From: Ian Stocks [REDACTED] **On Behalf Of** FRS Water and Access
Sent: 08 July 2021 11:37
To: Planning.Responses <Planning.Responses@arun.gov.uk>
Subject: Planning consultation - P/95/21/PL Bowley Farm Bowley Lane South Mundham Chichester PO21 1NB

Having viewed the plans for planning application P/95/21/PL, and wanted to inform you there is insufficient supply of water for firefighting in the area, the supply of water i.e. a fire hydrant should be within 90 metres of a commercial properties, currently the nearest fire hydrant is 540 metres away.

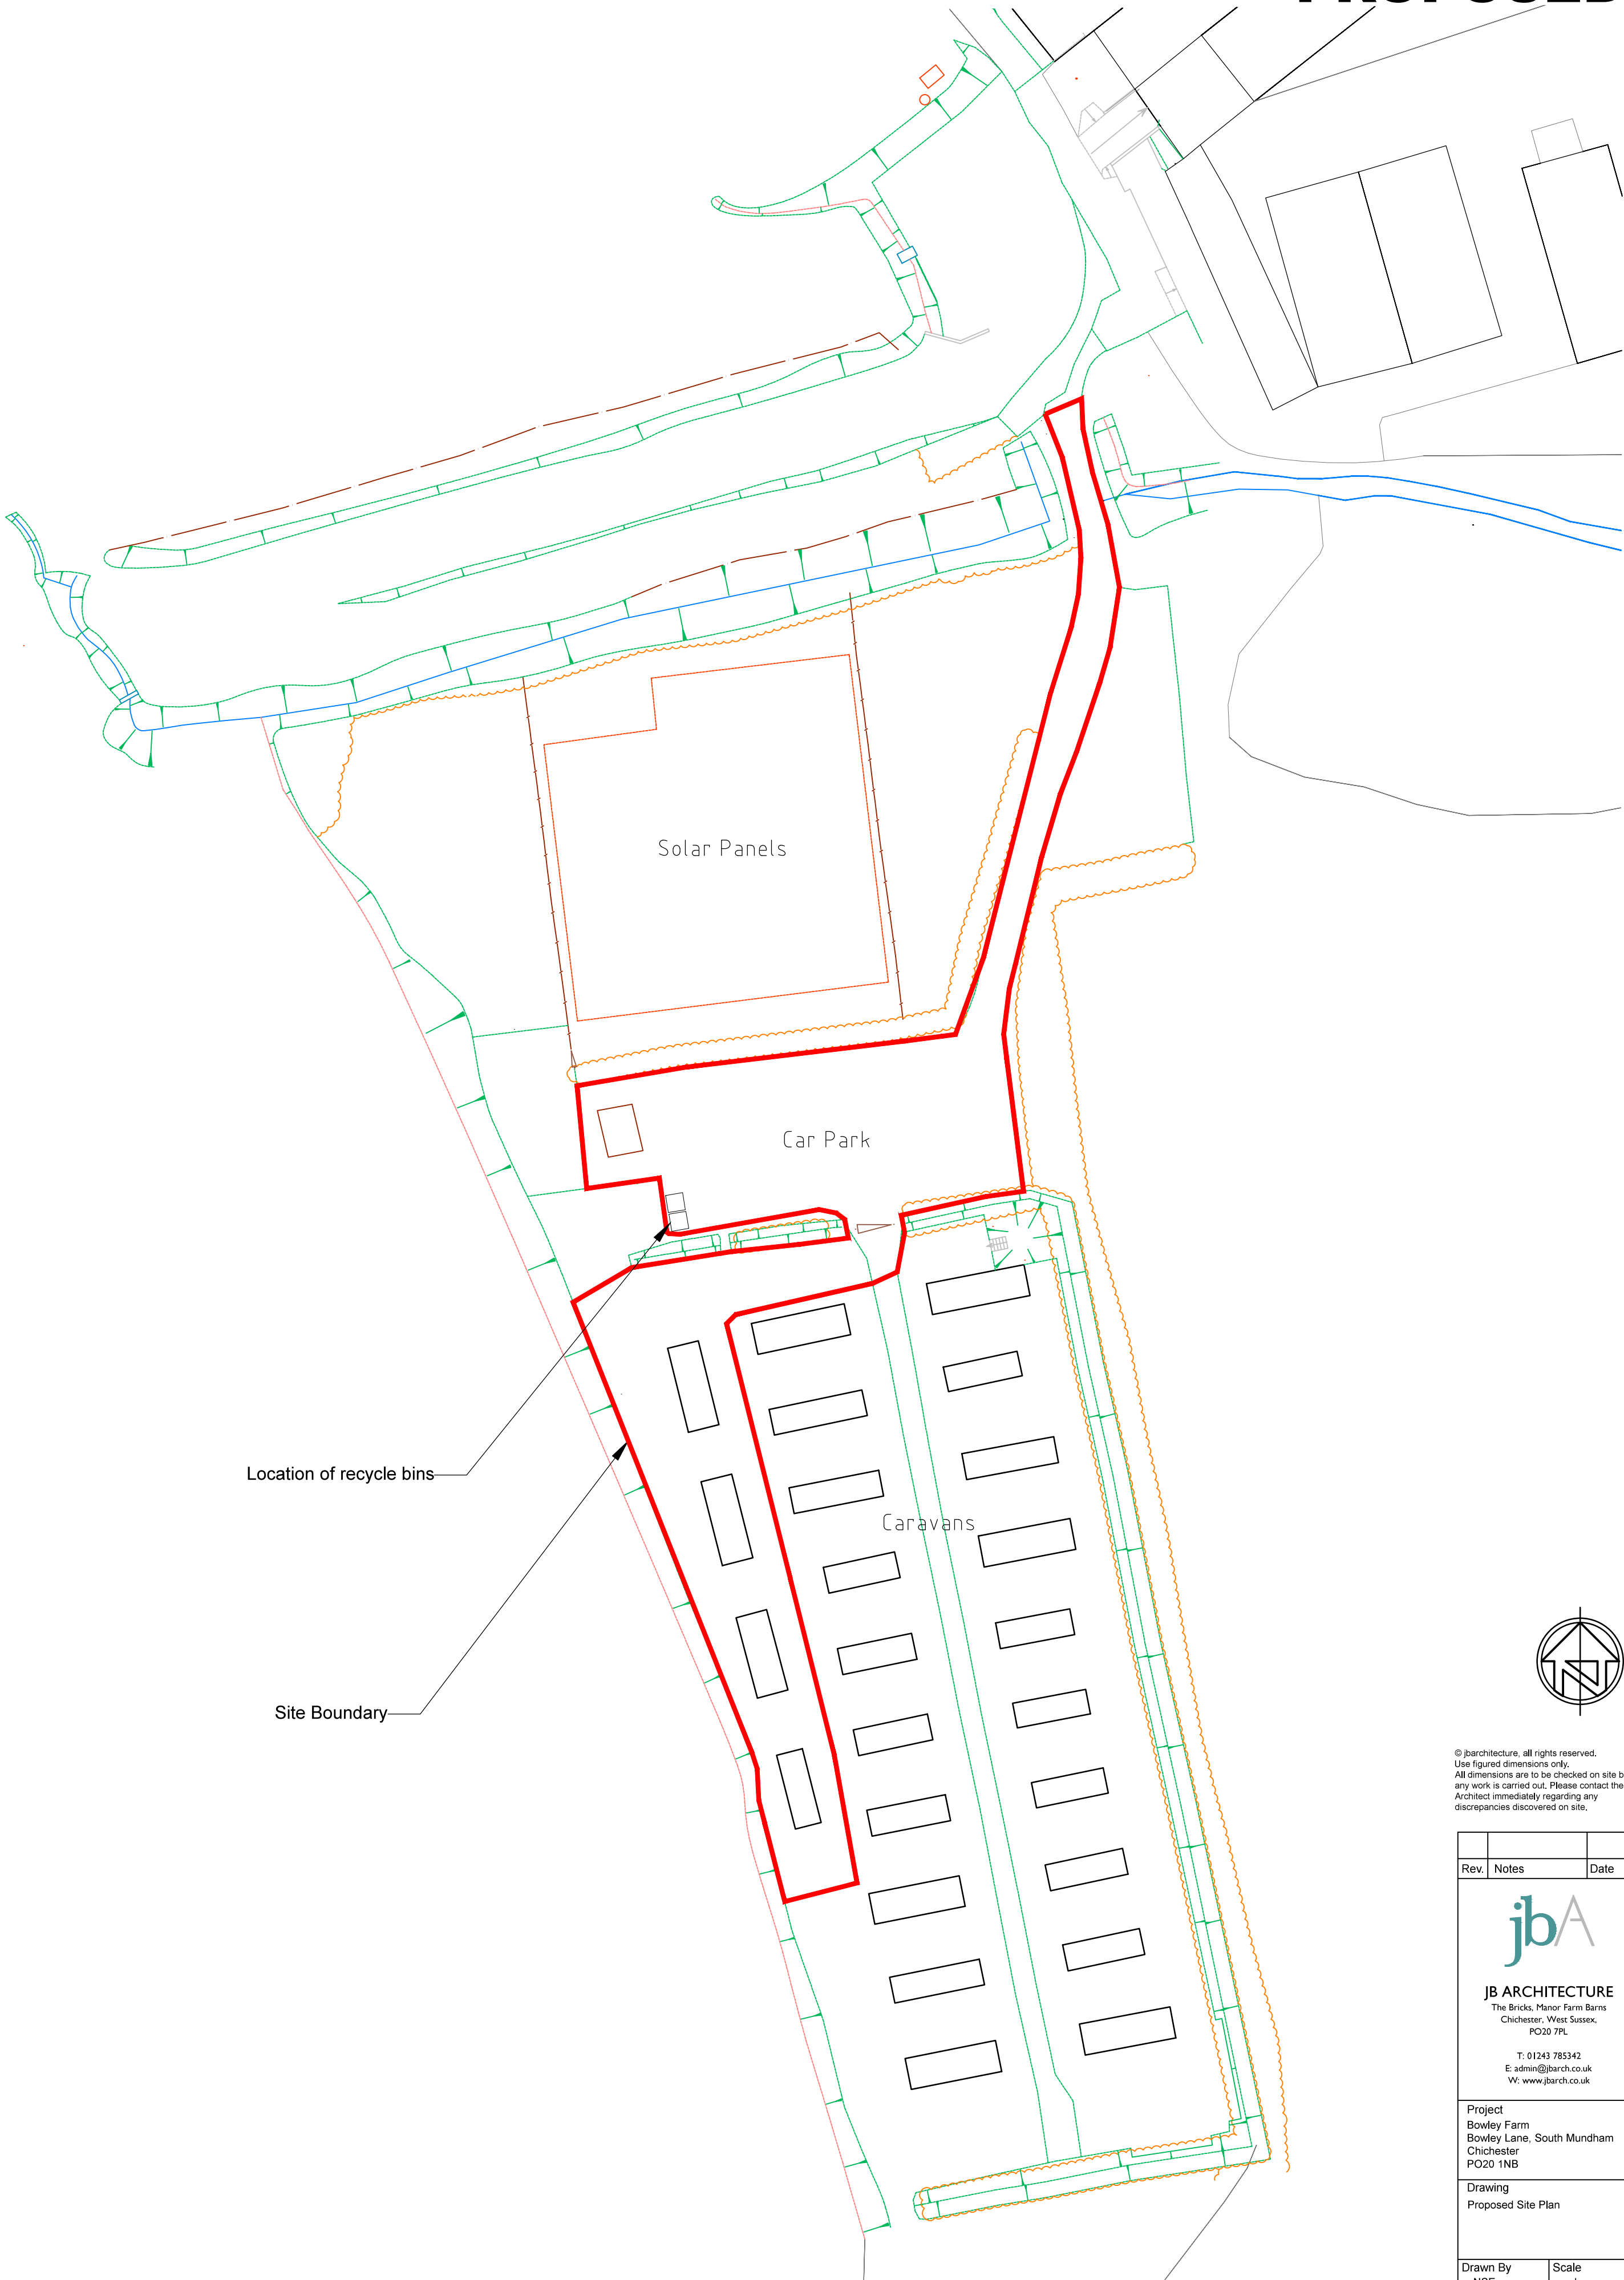
I appreciate this is for an additional four caravans to be used for countryside workers, therefore this is to inform you, the developer and the owner / occupier of this short fall. In the event of a fire there is a possibility the fire appliance may run out of water before the fire is extinguished. The Fire Appliance only carries a certain amount of water and water supply hoses, that is why we require a water supply within this distance. As the nearest fire hydrant is 540 metres away, the Fire Crew would need the attendance of another three fire appliances to have sufficient water supply hoses to reach the hydrant.

Evidence will also be required that Fire Service vehicle access meets with the requirements identified in Approved Document B Volume 1 2019 Edition: B5 Section 13, including Table 13.1 and diagram 13.1.
